M42 Junction 6 Development Consent Order

Draft Statement of Common Ground – Solihull Metropolitan Borough Council

HE551485-ACM-LSI-ZZ_SW_ZZ_ZZ-RP-DC-0031

June 2019

Drawing Title  
**REVISED ACCESS ARRANGEMENTS FOR FOUR WINDS AND GAA**

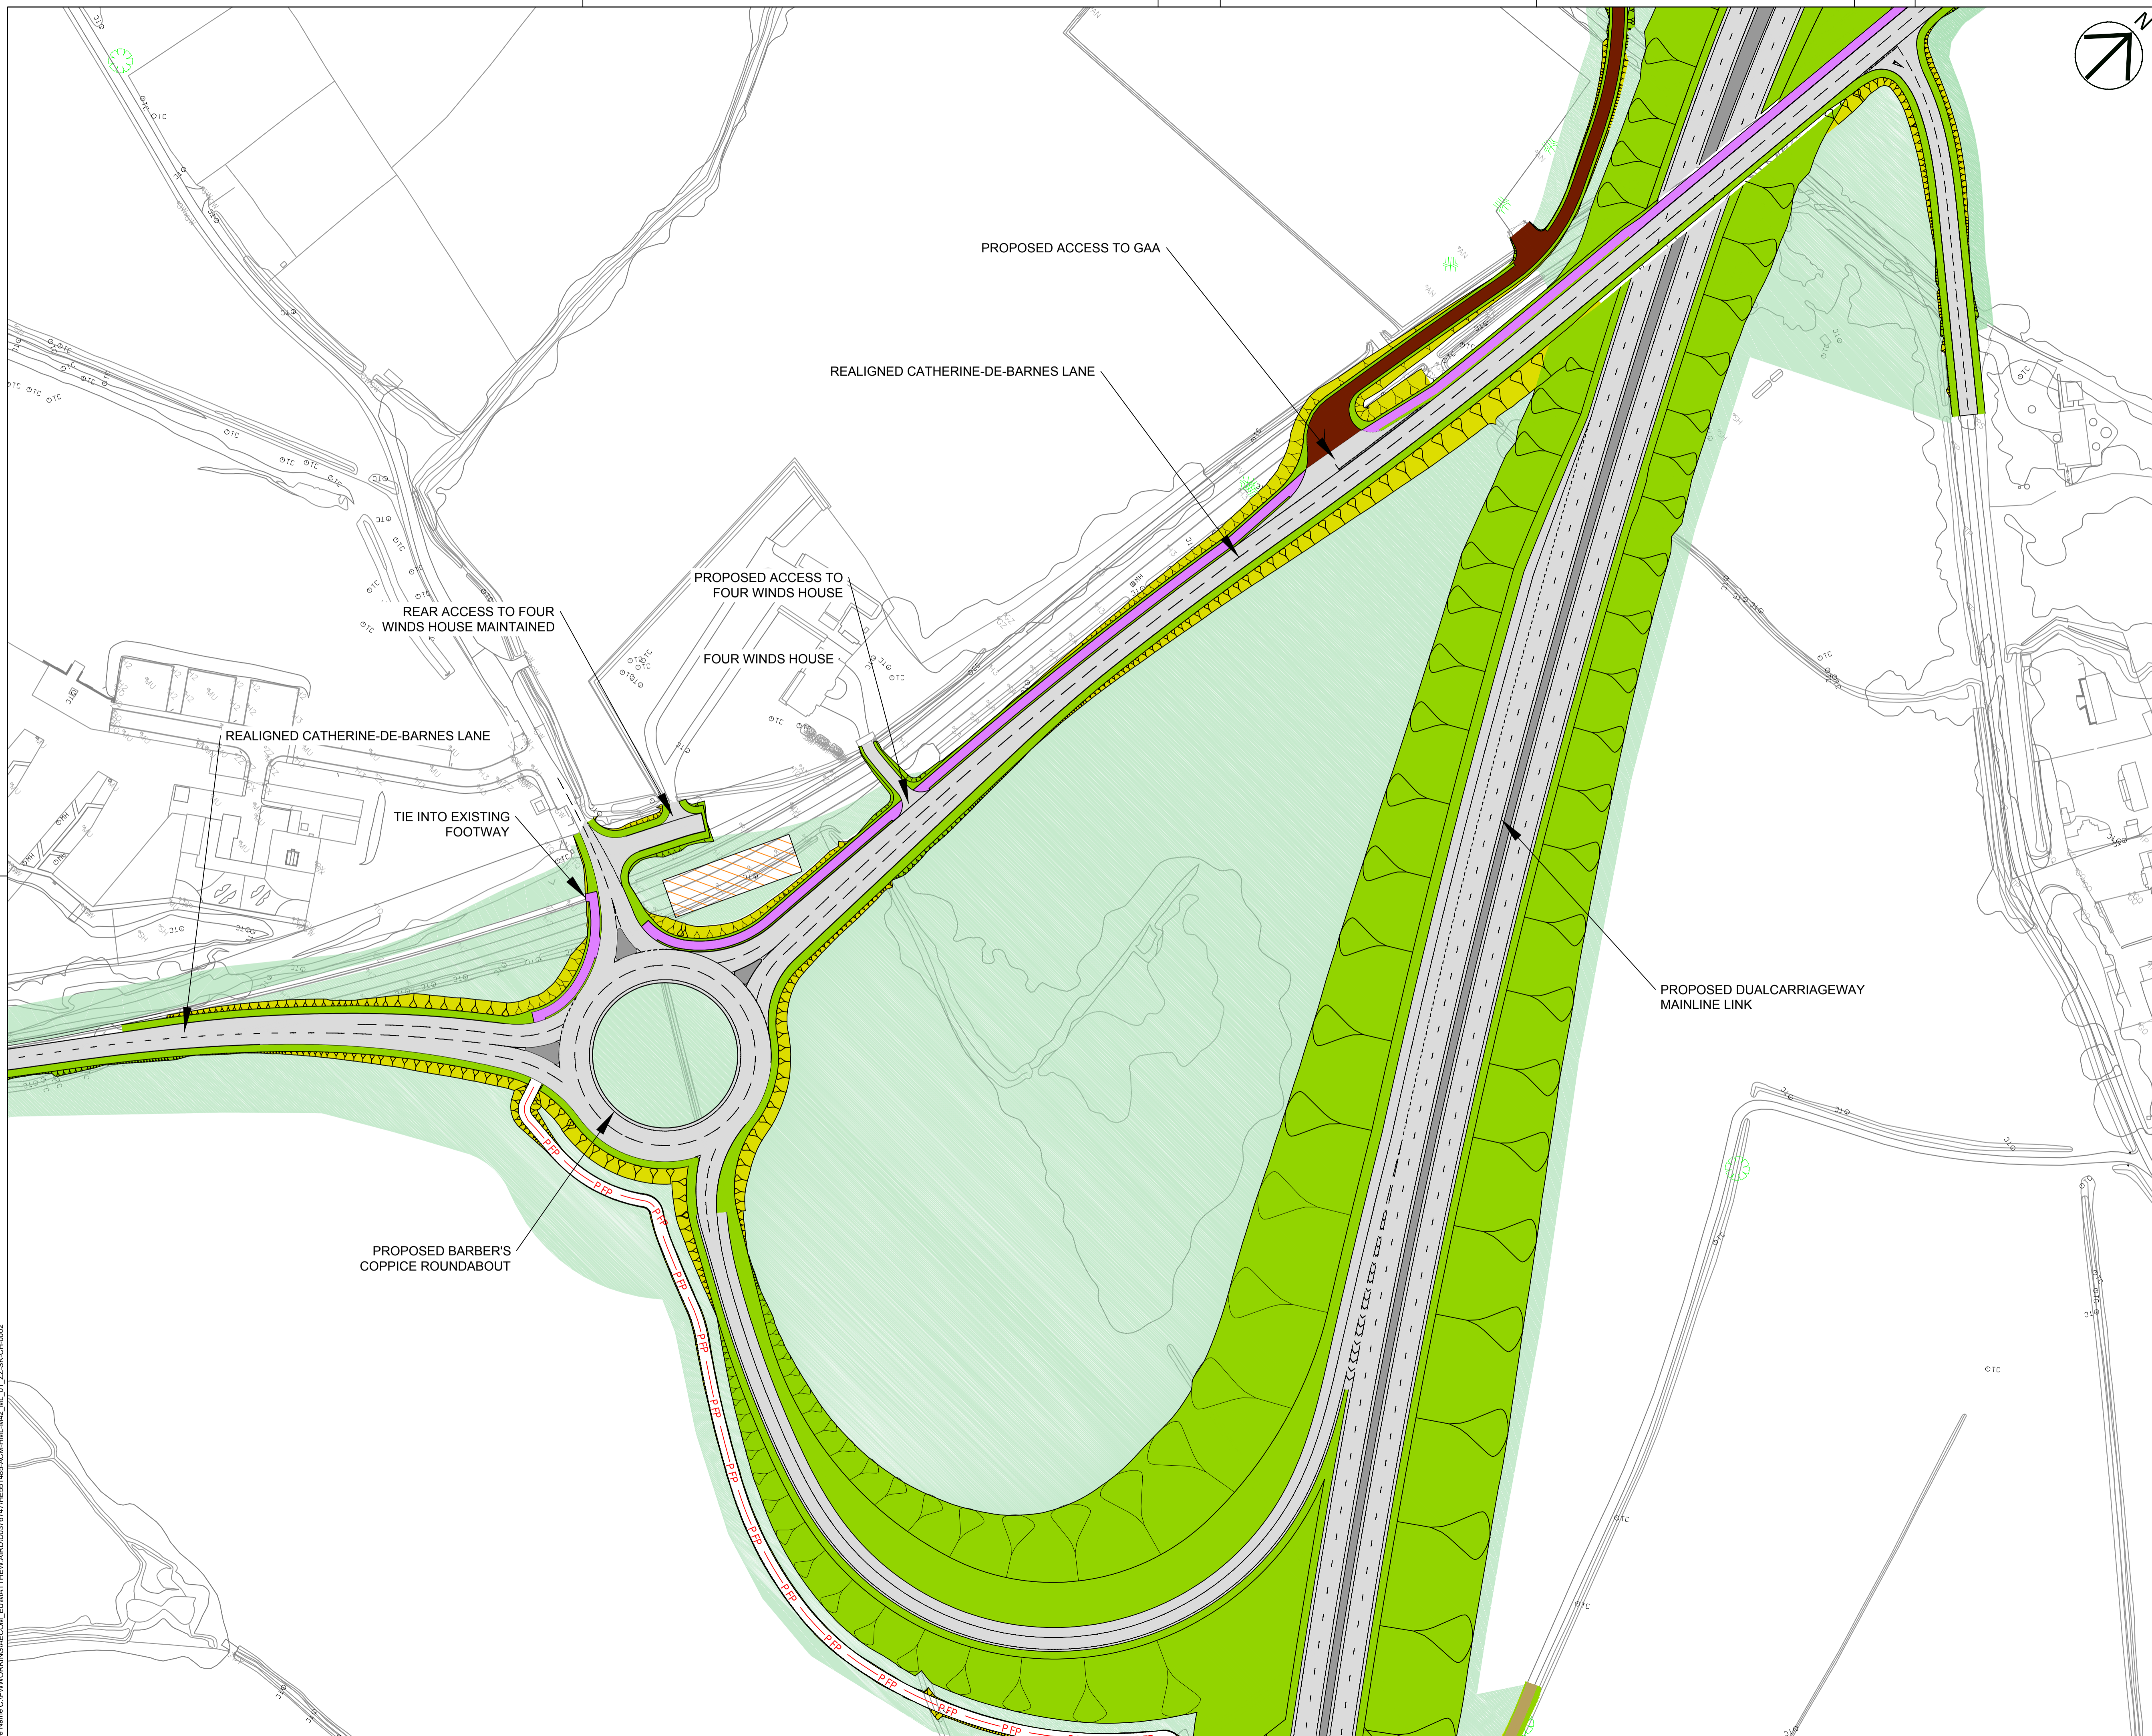
Design			
<p>Haven Caravan Park secondary access</p>	<p><u>A secondary access is welcomed and would be supported by SMBC, there would clear highway benefits if this were to be made permanent.</u></p> <p>SMBC has concern regarding the suggested revised access as it is on a bend and there will presumably be TM in place as well with the proposed bridgeworks. We discussed another option of an approach via Old Clock Lane but this is likely to raise an objection from the two properties nearby in Old Clock Lane. SMBC has highlighted Catherine-de-Barnes Lane in red on the plan that Highways England sent to SMBC and wondered if Highways England could consider a temporary access over the land shown in yellow – part of this will also be the PMA in the final scheme. SMBC has also requested a one way system through the caravan park for safety reasons and would like</p>	<p><i>Highways England has confirmed that a temporary secondary access to the site during construction would be beneficial.</i></p> <p><i>Highways England will consider whether there is potential for this access to be made permanent.</i></p>	<p>Under Discussion.</p>

Indicative proposals for main compound and offices for M42 J6 Improvement Scheme

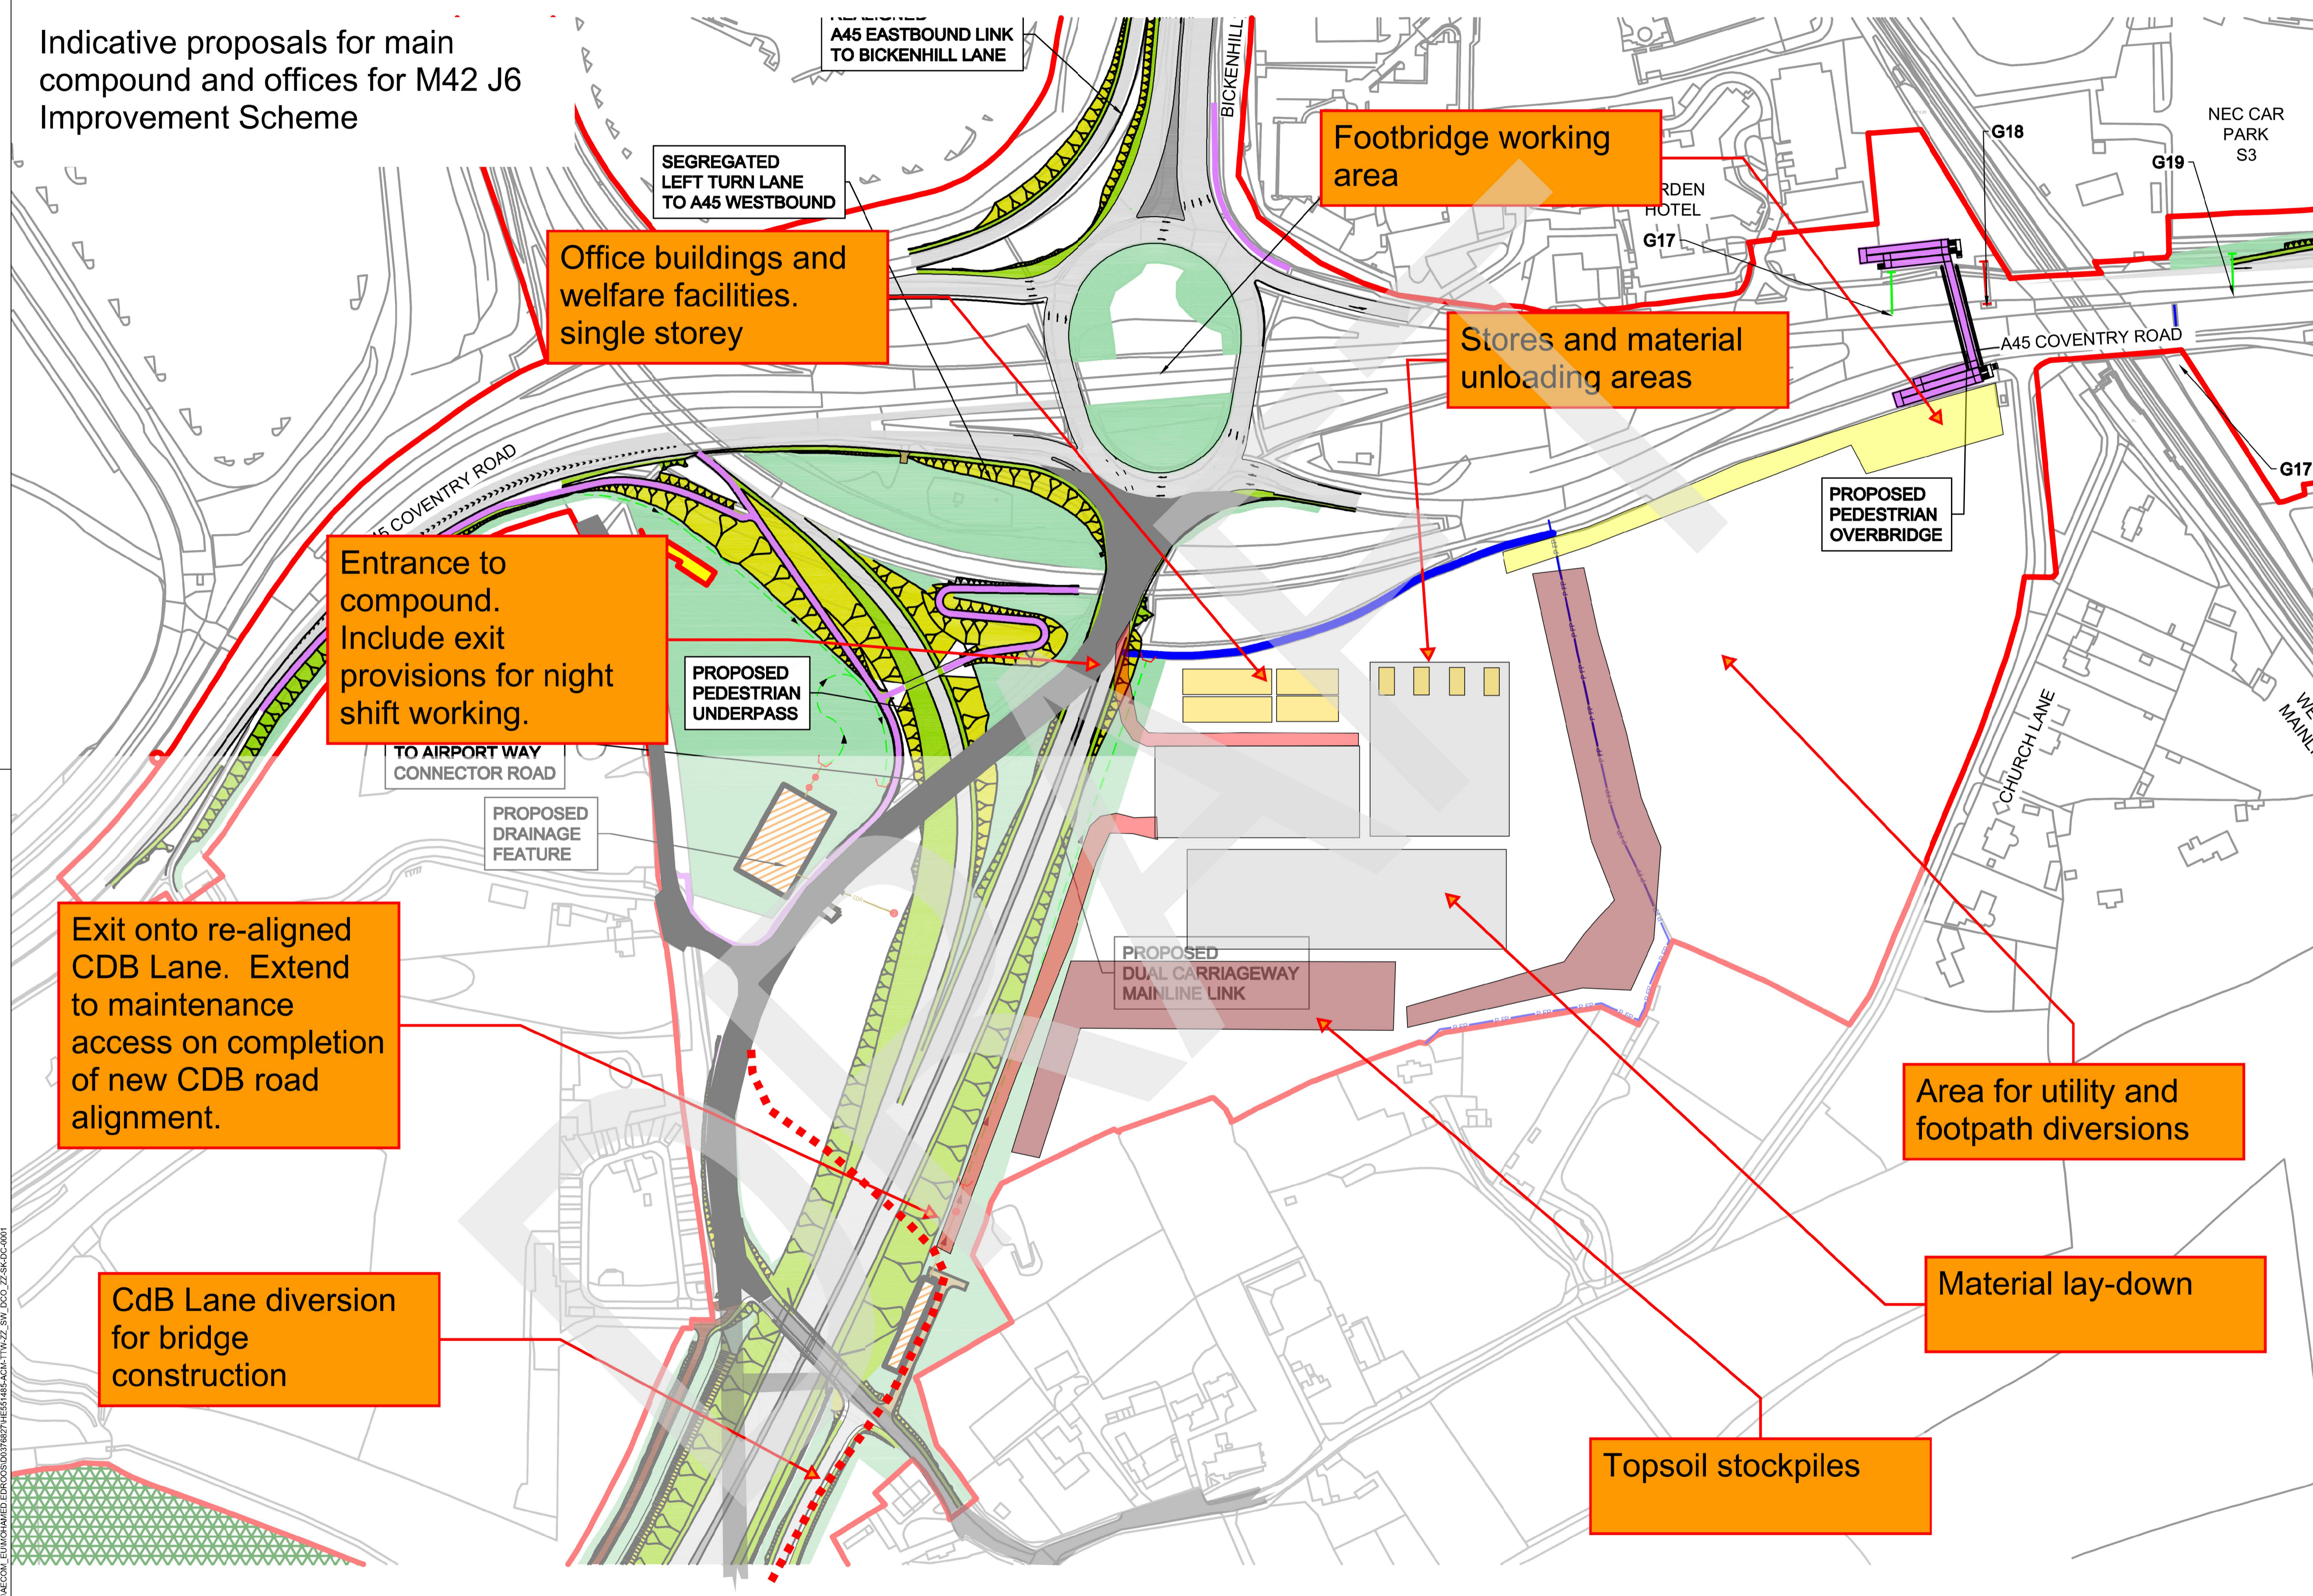
<p><u>2. Construction Compounds – SMBC requests that a meeting is held</u> with Highways England to discuss the approach to construction, in particular the location and rational for construction compounds. <u>Theis meeting covered is needed to understand</u> construction methods and the necessary mitigation measures for</p>	<p><i>Highways England agrees that such a meeting would be beneficial.</i></p> <p><i>Highways England would like to draw SMBC's</i></p>	<p>Under Discussion.</p>

Sub-topic	SMBC Comment	Highways England Response/Actions	Status/Agreement
	<p>compounds. <u>Compounds – SMBC and local residents were concerned over the extent of the proposed main compound and its proximity to local residents. The Council have requested details from Highways England of the assessment of other locations for the compound. They have also asked Highways England if they had considered a compound near the new Junction 5a. SMBC understand :-</u></p> <ul style="list-style-type: none"> <u>Order provides the power to create the compounds. The Main site compound north of Bickenhill is not a construction compound but would include storage of materials and would provide staff facilities. It is proposed to include topsoil bunds around the southern perimeter of approx. 2-3m height that would also provide screening for Bickenhill residents.</u> <u>Noise & hrs of operation – these are defined in the DCO and was assess in the ES.</u> <u>Light pollution – low level LED lights with baffling plates proposed to be used. There is also a safeguarding issue as this is on the Airport</u> 	<p><i>attention to the Outline Environmental Management Plan which includes extensive measures to control environmental effects during construction</i></p>

Sub-topic	SMBC Comment	Highways England Response/Actions	Status/Agreement
	<p><u>approach route.</u></p> <ul style="list-style-type: none"> • <u>Other locations – HE preparing a paper for the EA – 5 locations – & addressing the use of the compound</u> • <u>Local field offices – HE will provide and agree details</u> • <u>J5a – HE will use Motorway for access for bridge beams etc.</u> 		
SSSI	<p>SMBC query whether the new solution for mitigating the impact on the SSSI would sufficiently reflect what has been lost, as well as how this solution would work. SMBC also query the wider implications that this alternative solution may have on the surrounding environment. SMBC have not been able to review the proposed mitigation but will be happy to review before next deadline</p>	<p><i>Highways England's advisors met with SMBC's Ecology Advisor on the 15th May to discuss this issue.</i></p> <p><i>It was agreed that Highways England would issue the updated version (Version 9) SSSI Technical Note, when produced. The SSSI technical should provide adequate response to SMBC's queries. It is intended that this Technical Note will be produced shortly.</i></p>	Under Discussion.
